WELWYN HATFIELD ACCESS GROUP
 Hazel Grove Community Centre
 hazel Grove
 Welwyn Garden City
 Hertfordshire AL7 2DG

7 September 2010

re: Planning Applications Received by Welwyn Hatfield Council

| Appn No. | Description and Location | Applicant |
|-----------------|---|--|
| S6/2010/1711/FP | Formation of replacement car park for business use including layout of additional parking area for residential occupiers, paths, landscaping and ancillary works. Land adjacent the viaduct Hatfield Park Church Lane Hatfield Hertfordshire AL9 5NB | Mr Paul Atton JB Planning Associates Ltd Chells Lane Chells Manor Stevenage Hertfordshire SG2 7AA |

DRAWING NUMBER:
045-VC-002 B

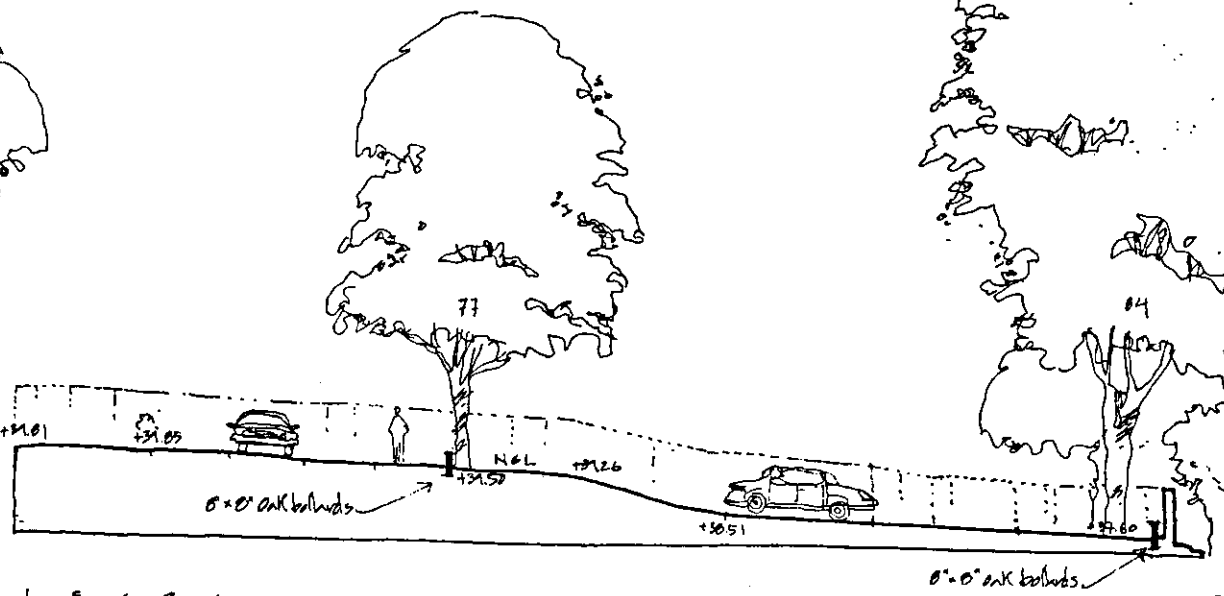
Looking at the accompanying drawings, there does not appear to be any provision for parking bays suitable for disabled people. Would you please advise us if this is the case, and if not where they are to situated?
